**From:** Katherine Rawlins  
**Sent:** 07 October 2011 10:33  
**To:** 'keith.trotma' [REDACTED]  
**Subject:** 64 Wroxham Way

The revised plan to show the west elevation (drawing PG4 dated 26 September) is a considerable improvement in design terms to the refused scheme.

DRWG P4

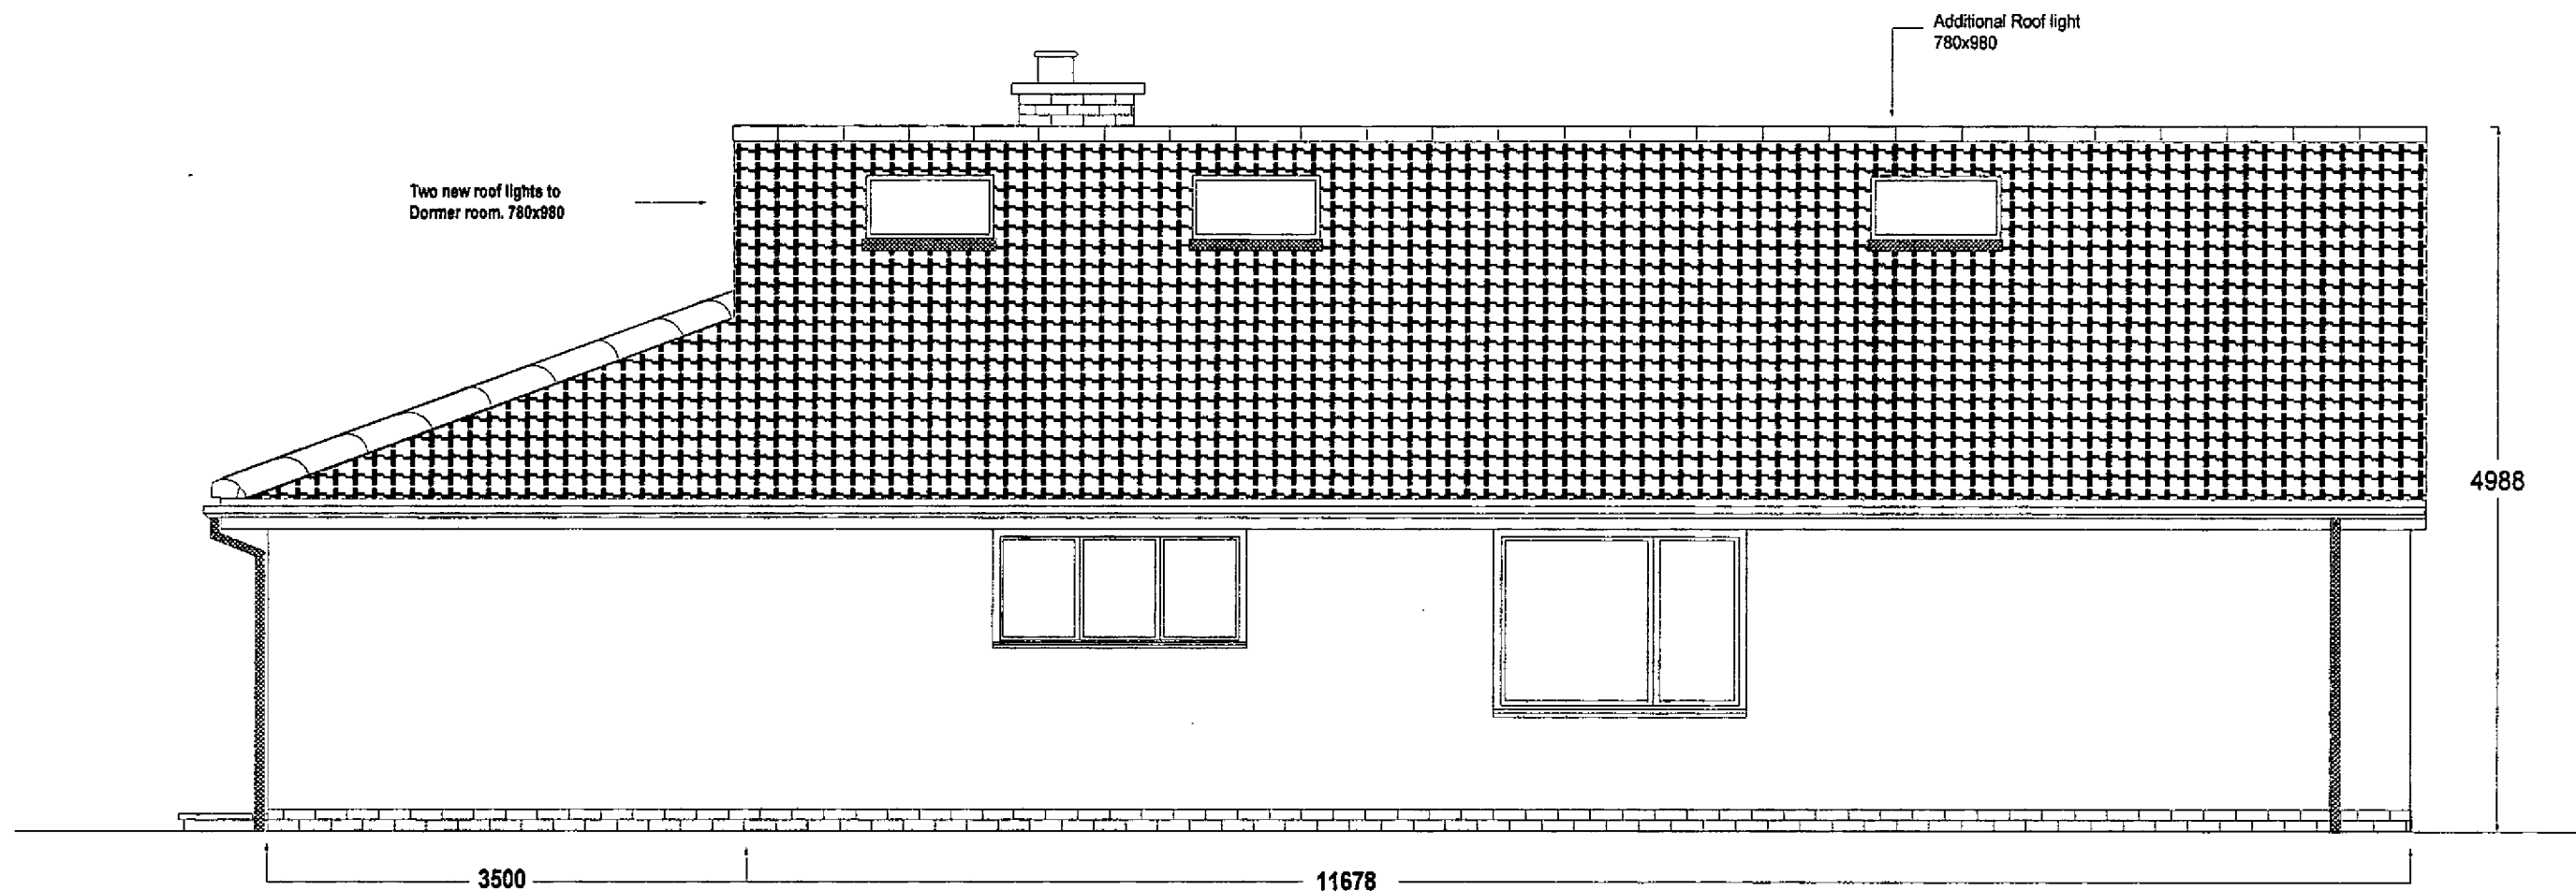
The amended height, depth and length reduces the bulk and scale of the dormer window. Whilst the dormer window would be visible from the streetscene, in my opinion, the revised scheme would be less overbearing, bulky and prominent.
